**Yorkshire Water Services
Developer Services
Sewerage Technical Team
PO BOX 52
Bradford
BD3 7AY**

**Your Ref: 2026/0491
Our Ref: B/01881**

134 Church Hill, Royston, Barnsley, S71 4AQ - (BARNS) - Change of use from Use Class C3 (Dwellinghouse) to Use Class C2 (Residential Institutions) to operate as a residential care home for adults and young adults with autism and learning disabilities, together with extensions, alterations and conversion of outbuildings, including retrospective planning permission for the erection of Outbuilding 2

Dwg No. Rev
GNH1-AVL-05-00G-DR-A-001 P01

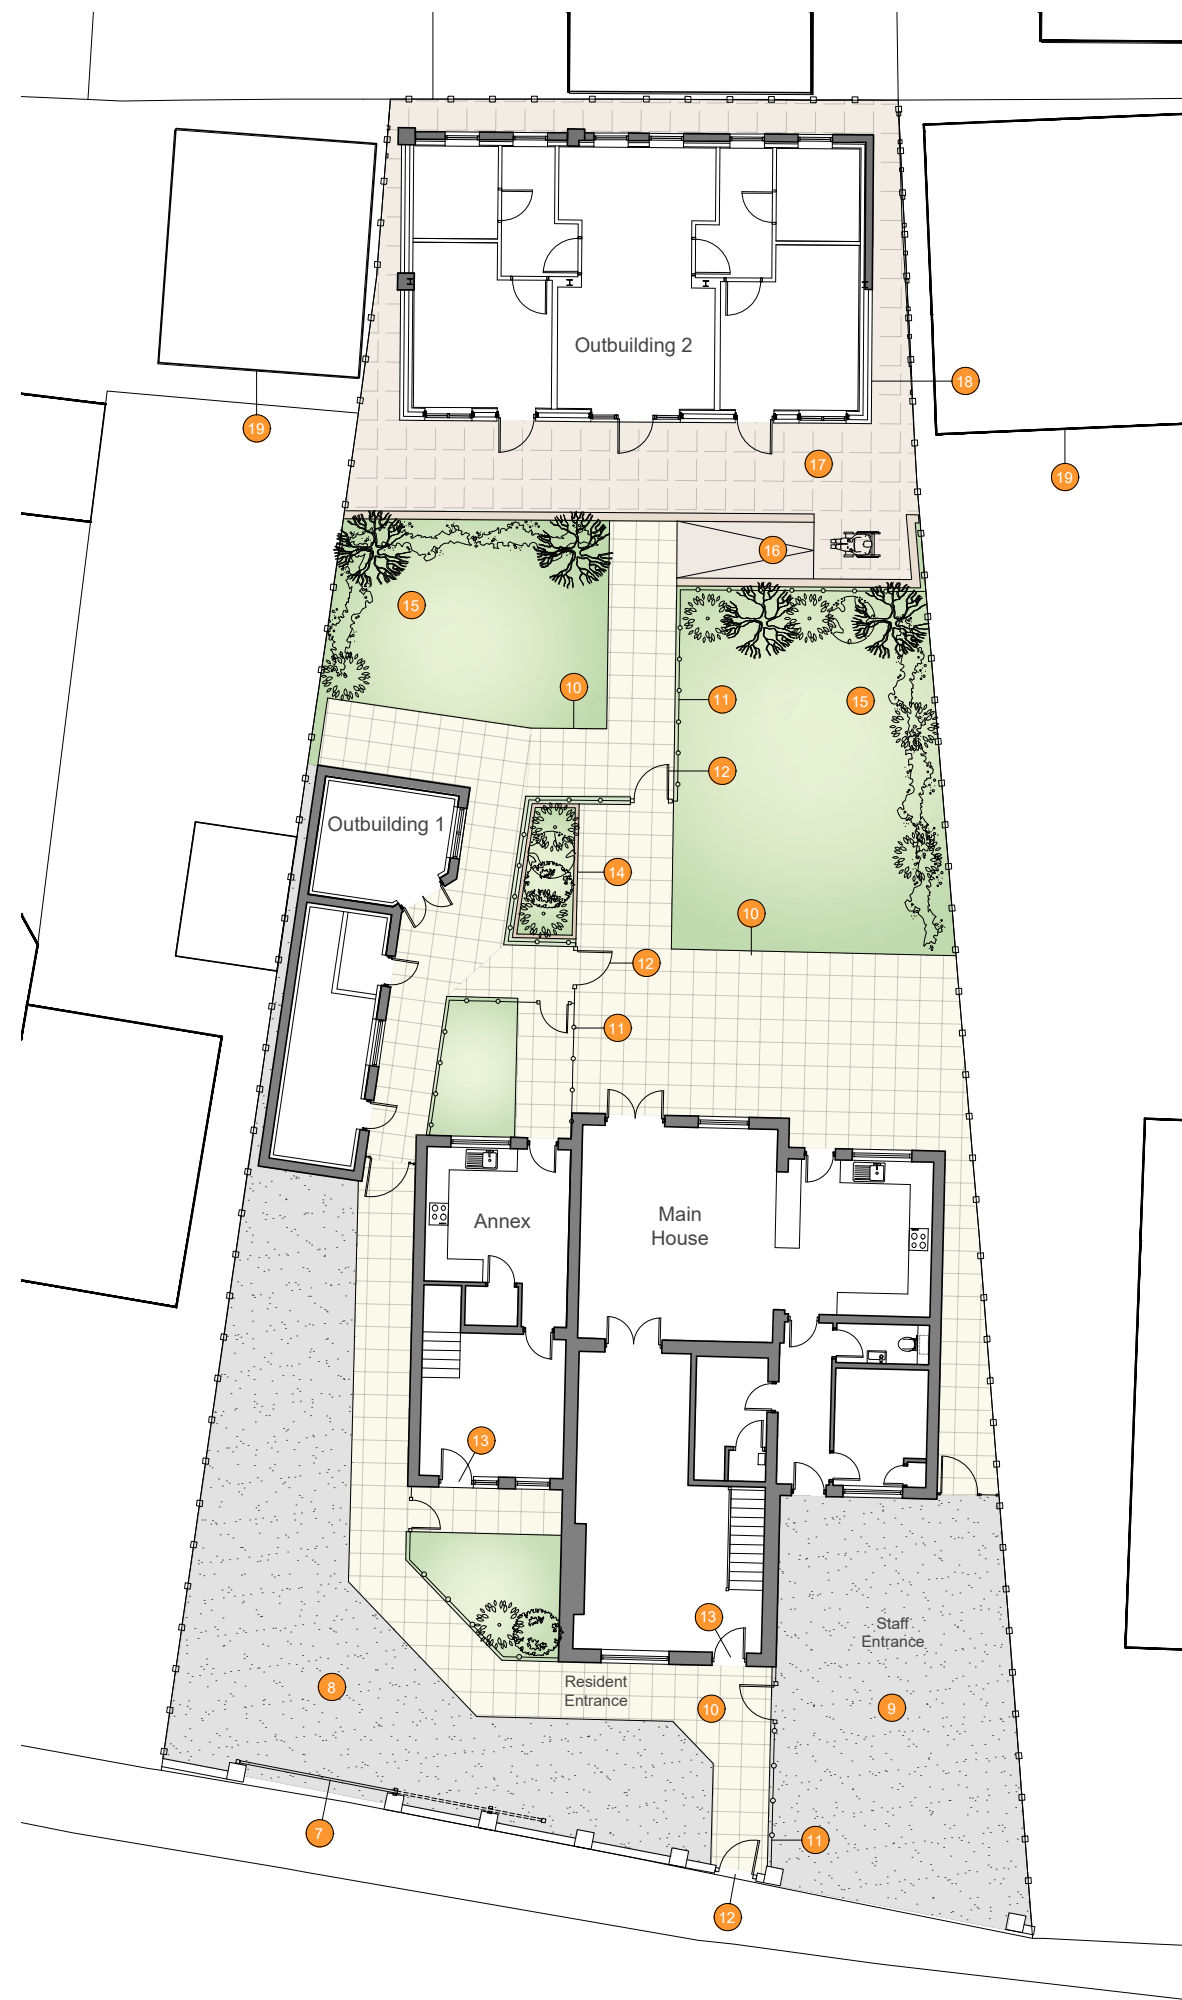
On the Statutory Sewer Map, there is a 375mm diameter public combined water sewer recorded to cross the site. It is essential that the presence of this infrastructure is taken into account in the design of the scheme.

It may not be acceptable to raise or lower ground levels over the sewer and we will not accept any inspection chambers on the sewer to be built over.

In this instance, a stand-off distance of 3 (three) metres is required at each side of the sewer centre-line and it may not be acceptable to raise or lower ground levels over the sewer, nor to restrict access to the manholes on the sewer.

In this instance, it would appear that the public sewer is unlikely to be affected by building-over proposals.
